Subject: Resubmission - DoC 3 - Wicks Farm

Please find attached a copy of the resubmission form for the Discharge of Condition #3 for Wicks Farm, Ford.

From: Stuart Magowan [REDACTED]
Sent: 21 August 2020 15:40
To: Paul Cann [REDACTED]
Cc: Anita Gardner [REDACTED] John Hall [REDACTED]; CEP | Reception
[REDACTED]
Subject: FW: 23314 Decision Notice DOC Individual Actual PLDNDOCIACT

CLIENT	DPS Limited
PROJECT	Wicks Farm Polytunnel Ford
TITLE	Construction Details Sheet 3 of 3
DRAWN	P Reynolds
DATE	Aug 2020
PROJECT NO.	23210
ENGINEER	S Burgess
CHECKED	SB
DWG. NO.	53
REV.	
SCALE	As shown @ A1

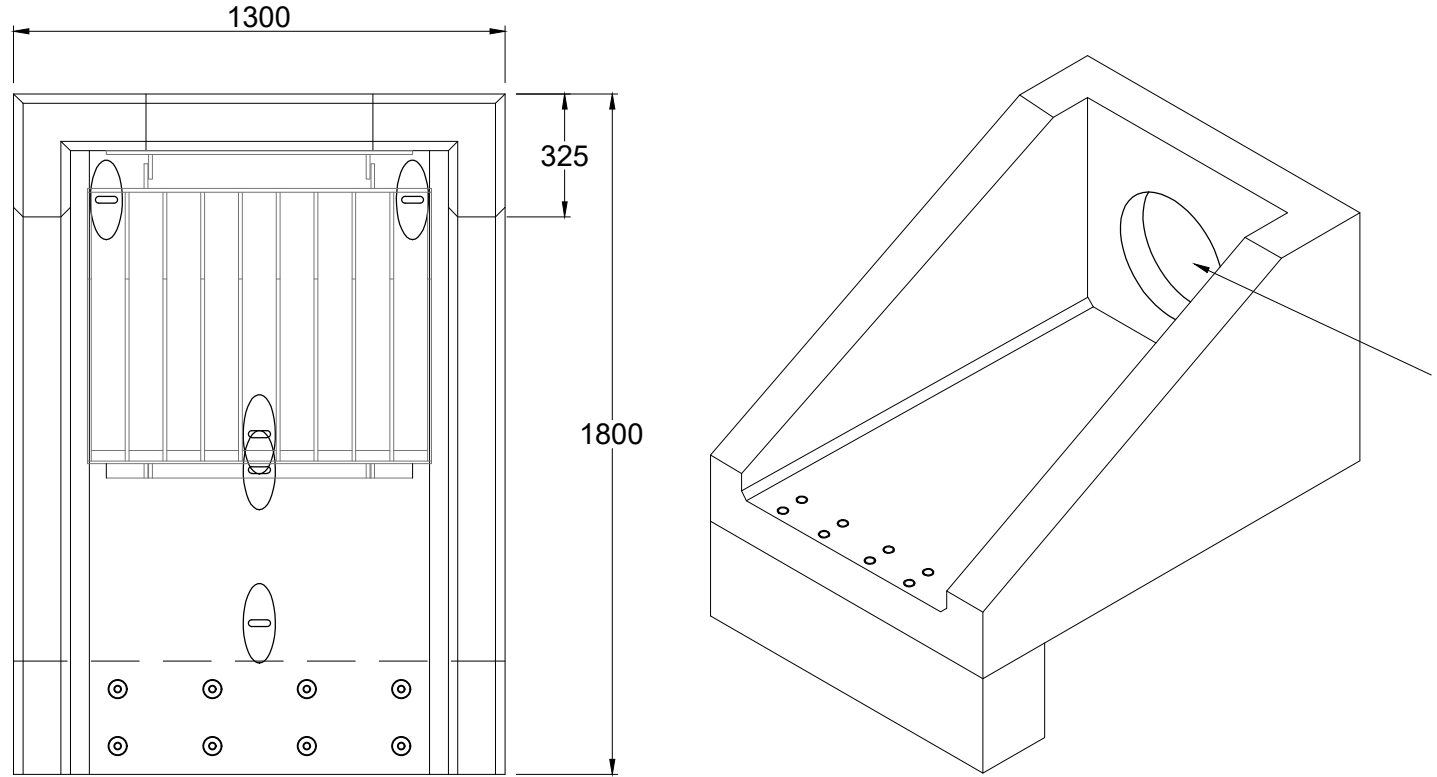
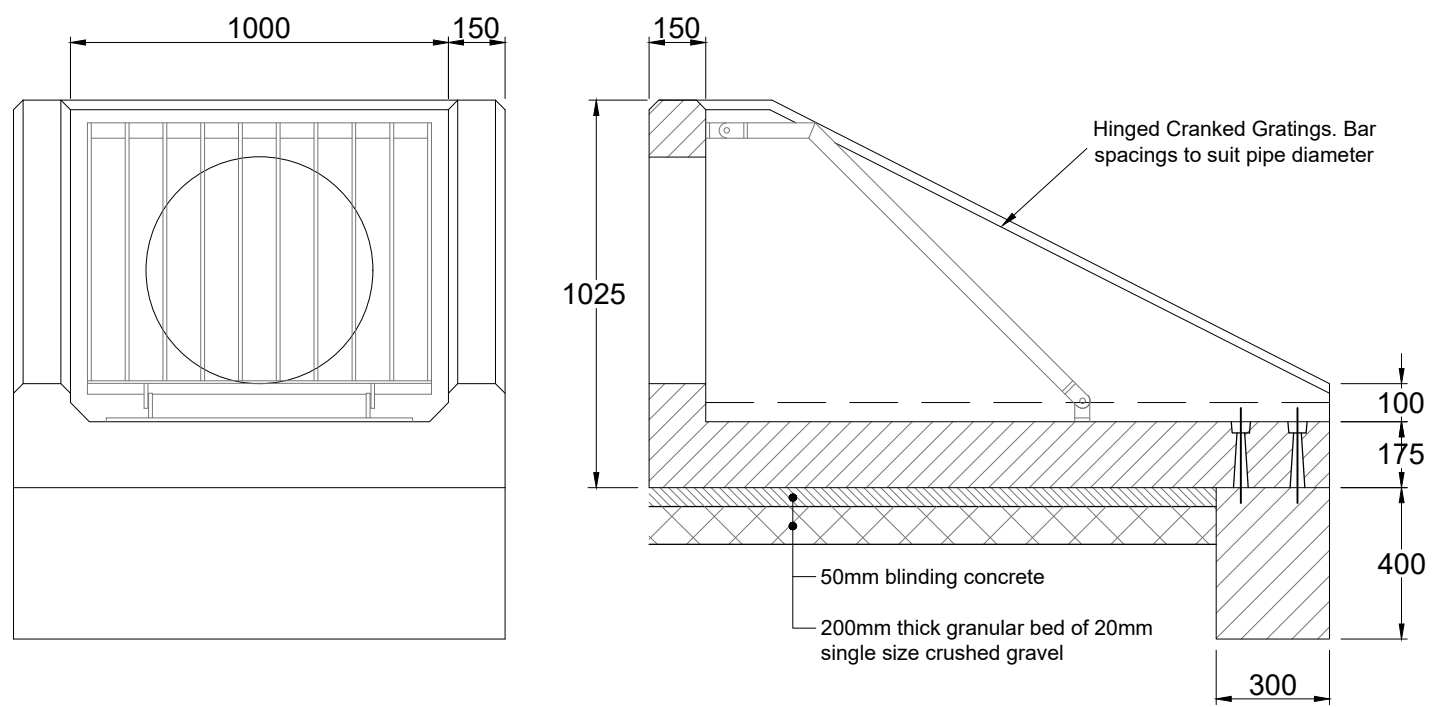
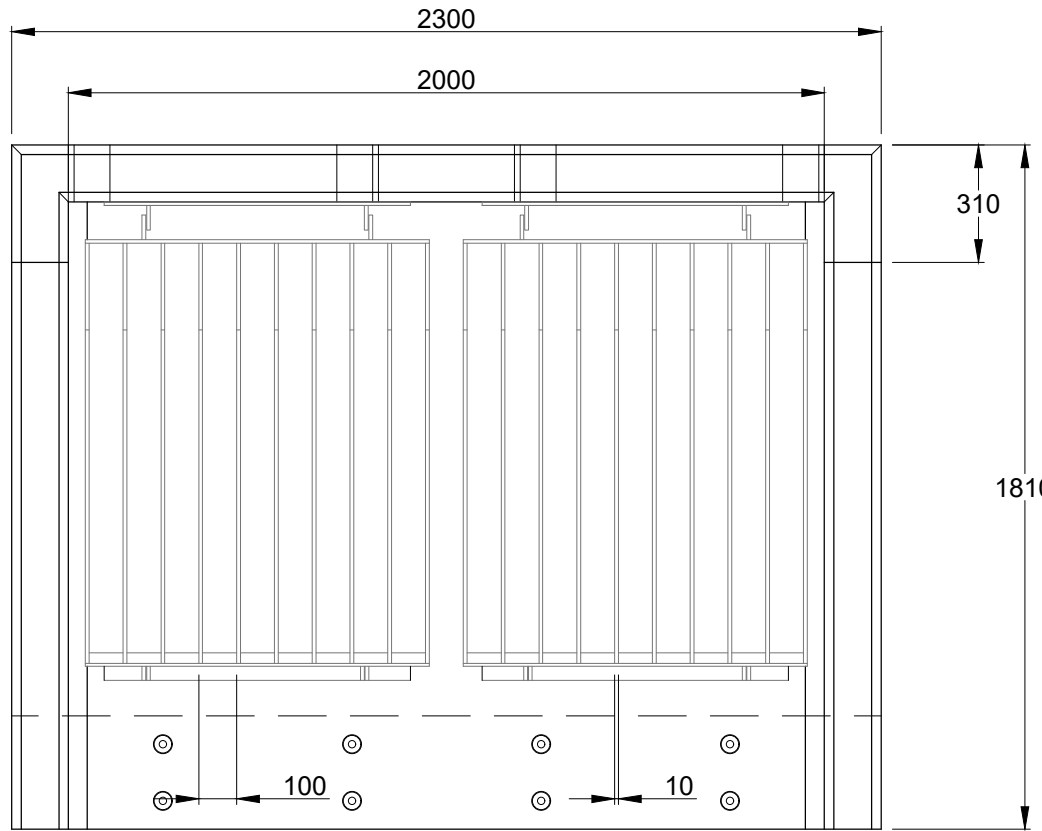
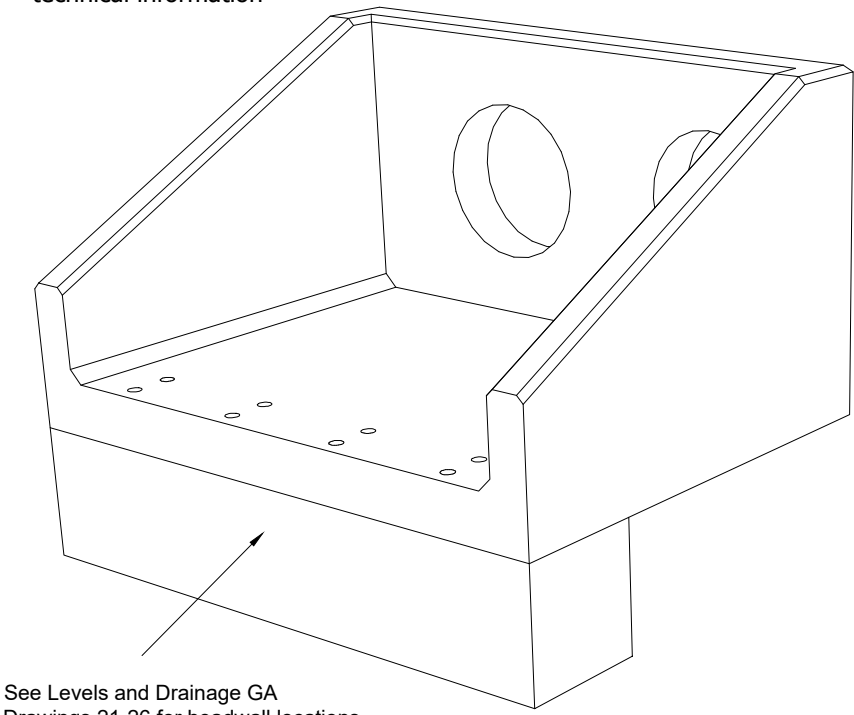
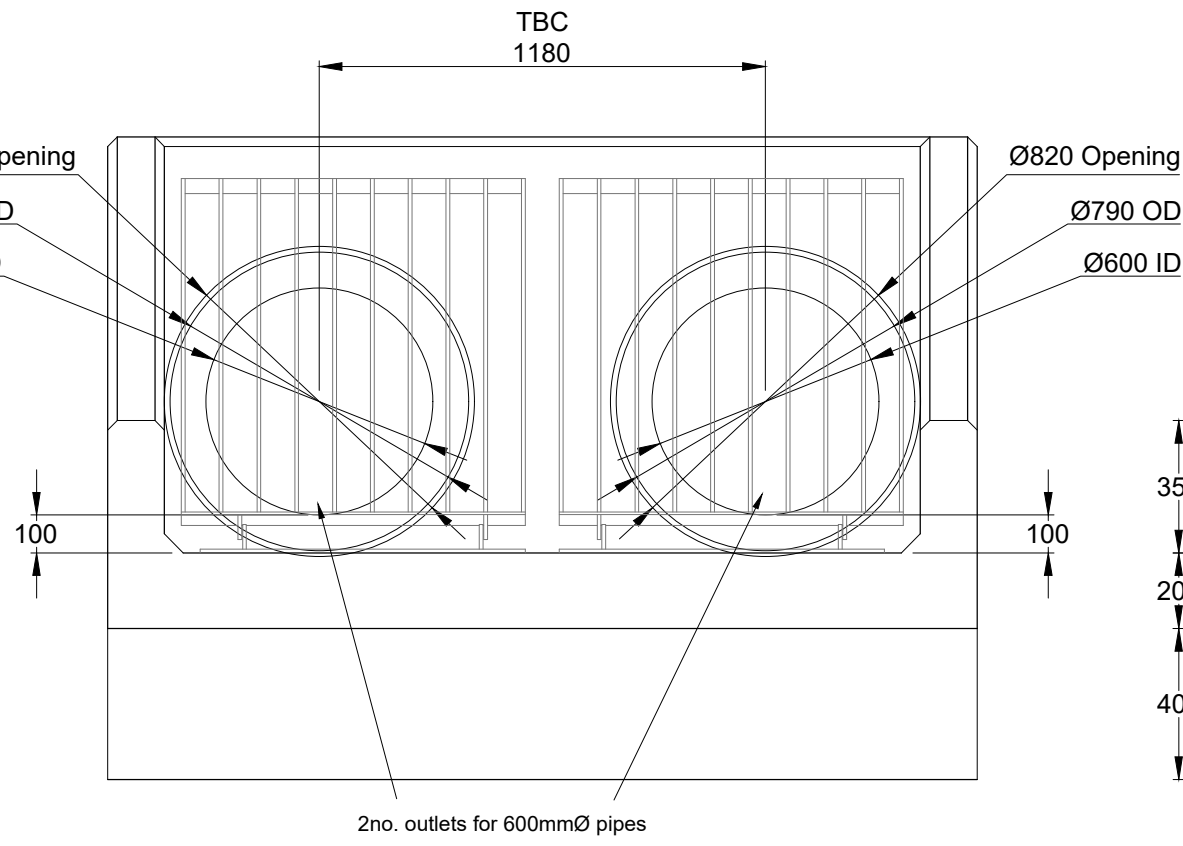
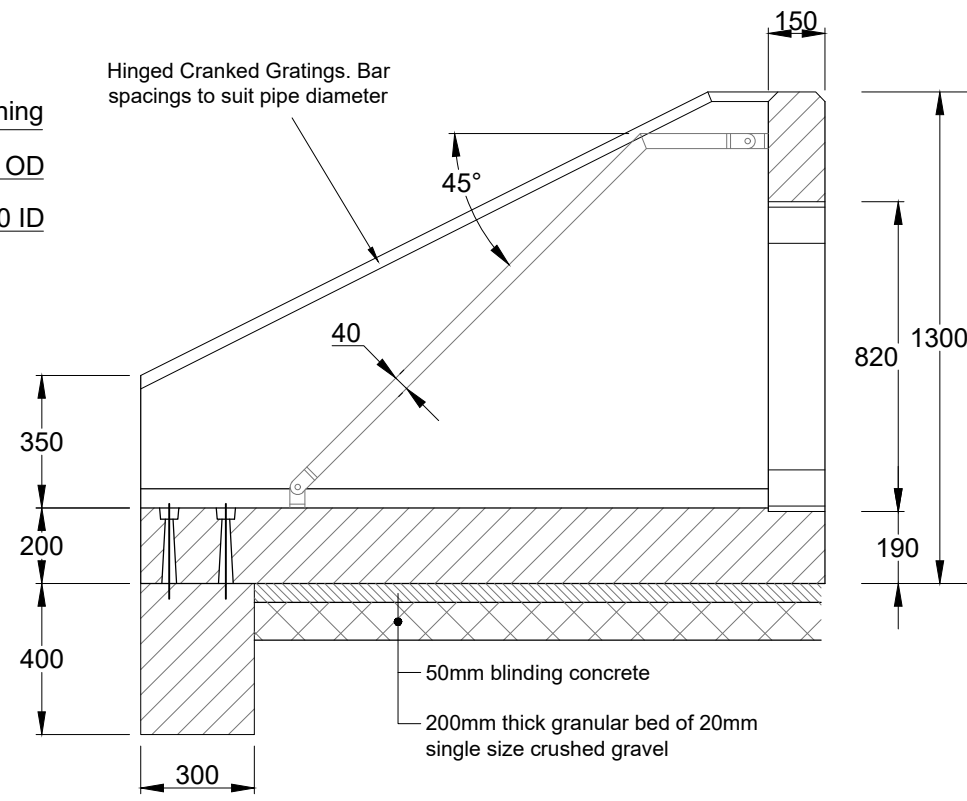
5. Overflow pipe from reservoir provide headwall with cranked grille with bar spacings to suit 150mm diameter pipe. Include construction detail. Detail of Althon Headwall R10CA with cranked grill and installation instructions provided on 13 July 2020 and are included in the link above on drawing 53.

LONG SECTION - WESTERN DITCH
(Horizontal Scale 1:500 / Vertical Scale 1:125)

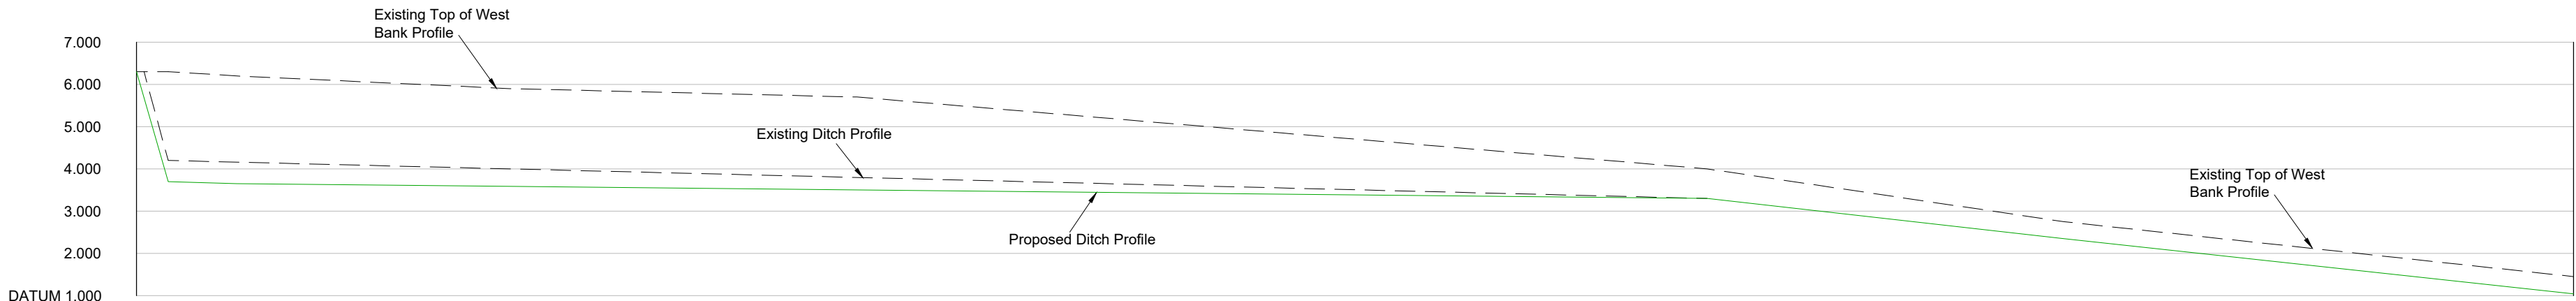
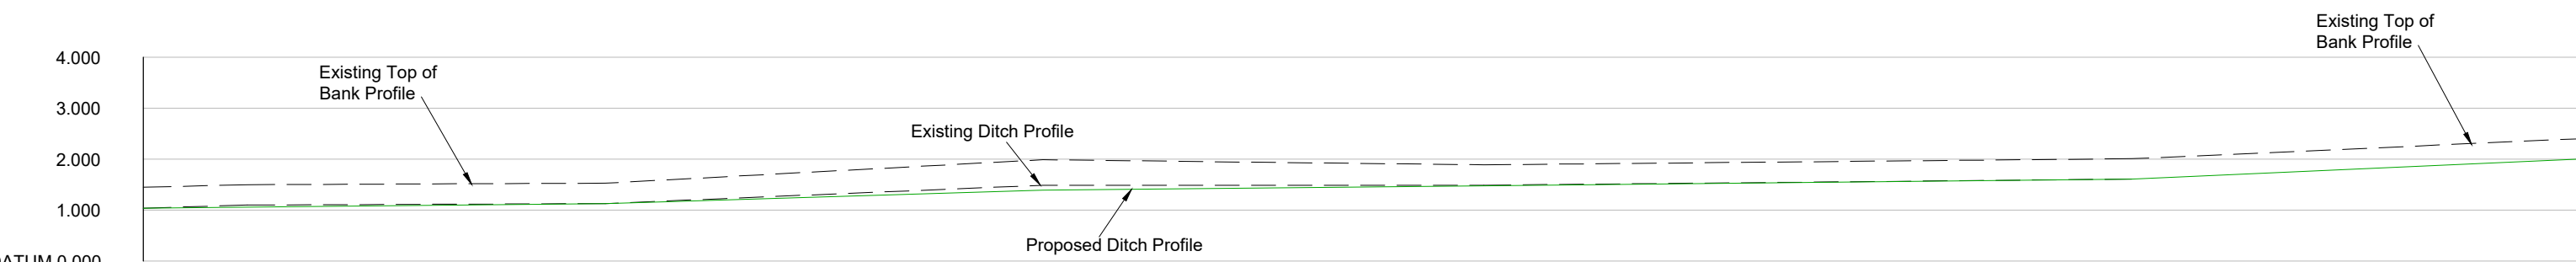
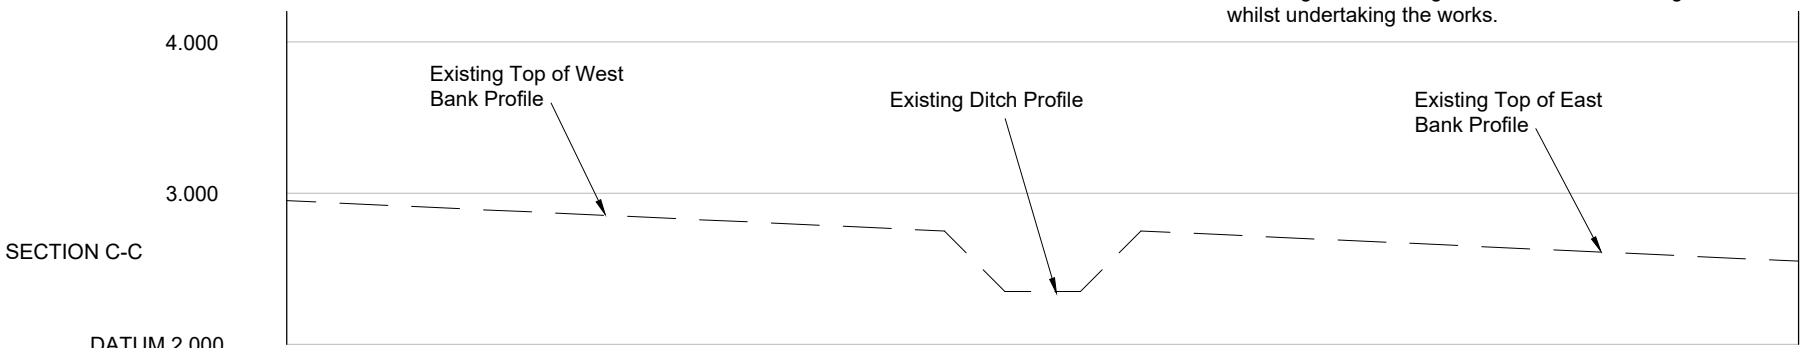
11. Provide longitudinal section showing existing and proposed bed levels. This is an existing ditch, we have provided the existing levels on the submitted drawings, long section is included in the above link on drawing 70.

13. If the ditch is being significantly deepened in places then the banks may need reprofiling to avoid them being too steep. Please advise and provide cross sections if necessary. Please also confirm that the regrading/profiling proposals will not have a negative impact on existing trees and their root systems. The ditch is proposed to be lowered locally at the inflow headwall by up to 500mm the gradient of the banks

remains consistent with other sections of the ditch. Cross sections are included in the link above on drawing 70.
